Reference No:	2023/44/92573/W
Site Address:	Crown Motors, Waterloo Road, Waterloo, Huddersfield, HD5 0AH
Description:	Discharge conditions 3 (marking out of parking), 4 (entry signs), 6 (kitchen ventilation), 7 (noise), 8 (external lighting), 9 (CCTV), 10 (vehicle recharging), 11 (Operational Management Plan) on previous permission 2021/91172 for change of use from former petrol filling station, car and van repairs/part sales and car sales pitch to hot food take-away (sui generis)
Recommending Officer:	William Simcock

DECISION – DISCHARGE OF CONDITION SPLIT DECISION

Officer Report 2023/92573

Figure 3. Location of the supplementary roof mounted supply and extraction equipment

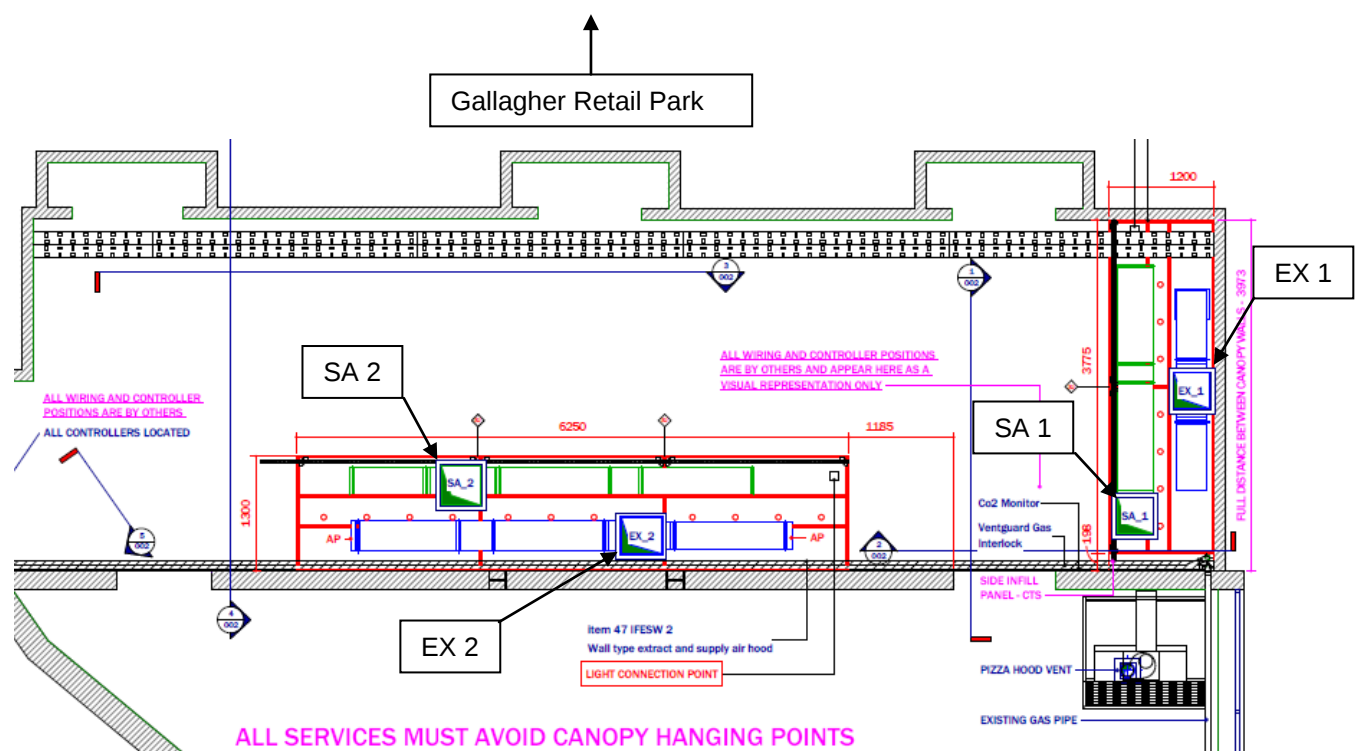
A BS4142 assessment was conducted on a worst-case scenario based upon the installed and commissioned kitchen extraction unit and, although tables 21 and 22 both refer to 4 Waterloo Road, they show a low impact and this is accepted. The report concludes (section 10) that the installation of the external roof mounted air handling equipment, including the indicated

attenuation measures relating to the supplementary air supply and extraction equipment, would result in no impact upon noise-sensitive receptors.

The report fulfils the requirements of parts (a) and (b) of the condition, and subject to the noise attenuation measures referred to being installed before the takeaway is brought into use and thereafter retained, the condition will be complied with.
